PLANNING CONSULTATION RESPONSE

Application No	2025/0992
Proposal	Change of use of existing Elderly Residential Care Home (Use Class C2) to Children's Residential Care Home (Use Class C2) and erection of a single storey extension to accommodate hydro pool, internal alterations, and associated works to car parking including the erection of retaining wall and installation of EV charging points (Amended Description and Plans).
Address	Woodlands Lodge, 106 Hawshaw Lane, Hoyland, Barnsley, S74 0HH
Date of Consultation Reply	15/06/26
Consultee	Highways DC

TITLE: Parking Layout

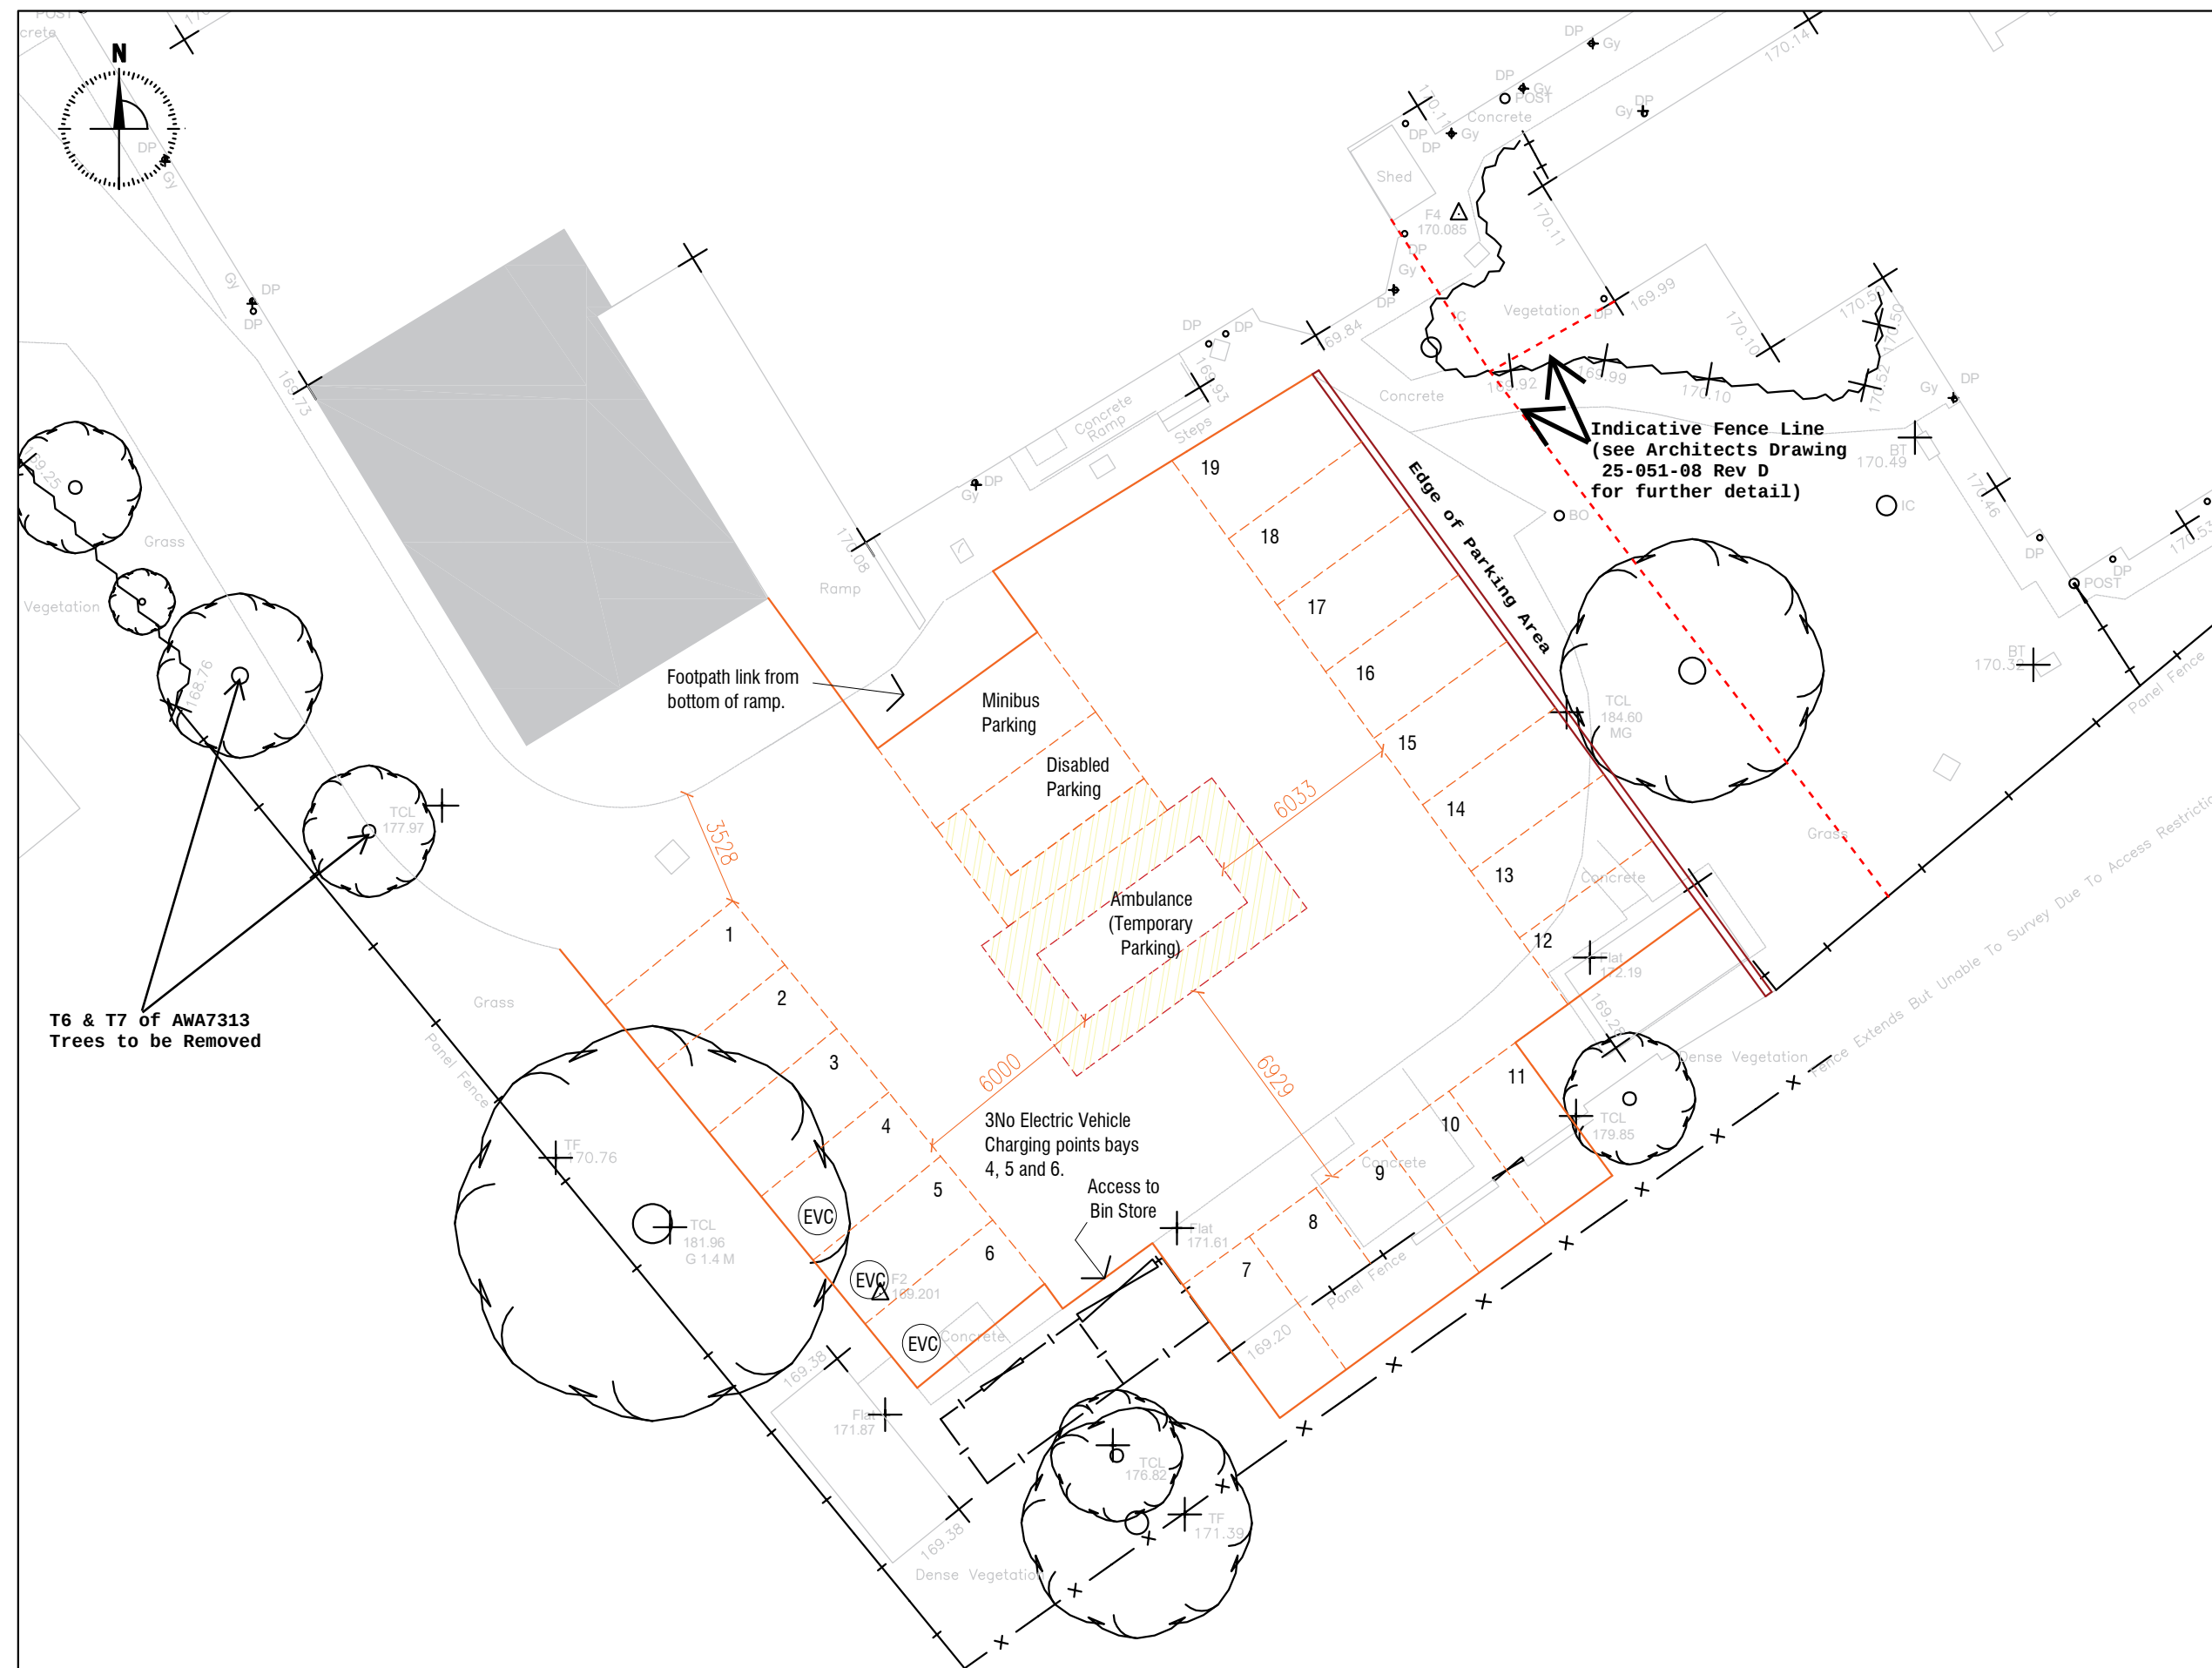
Drawing no. 026-00017-001 Rev B supplied by Fairfield Associates shows an amended car park layout that retains 19 regular parking spaces plus one disabled parking space, and provision for an ambulance and a minibus. The footprint of the parking area isn't changed, so this formalisation of the provision is seen as a benefit to the overall site design.
